Our reference: DOC15/253911-02  
Contact: Jacqueline Roberts

I refer to the Department of Planning & Environment's (DPE) correspondence in regards the proposed modification (SSD 6078 MOD 3) by Goodman Property Services (Aust) Pty Ltd to modify the development consent for its Warehouse and Distribution Centres at Horsley Park, notably warehouse 2B, sent on 8 July 2015.

Figure 1 - Approved site plan

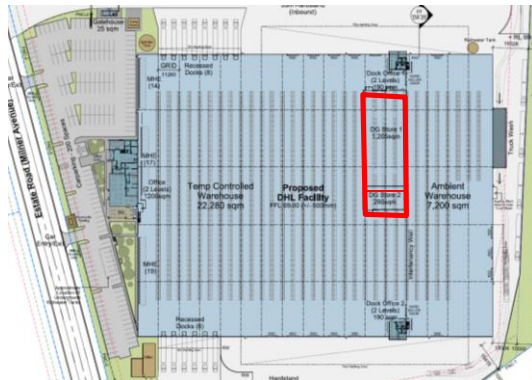
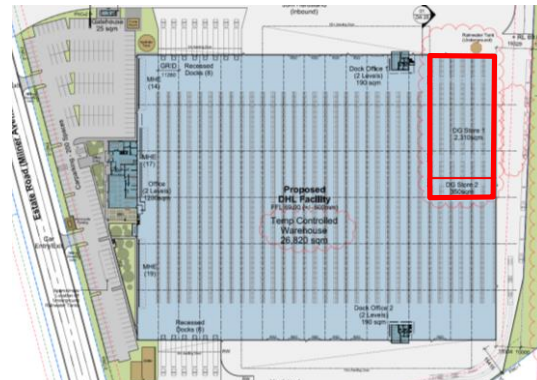
The Environment Protection Authority (EPA) notes that the proposed modification includes an increase to its Dangerous Goods (DG) Store from 1,495m<sup>2</sup> to 2,660 m<sup>2</sup>. The EPA advises that its comments outlined in its letter dated 24 April 2015 to the DPE are still applicable and the EPA does not have anything further to add.
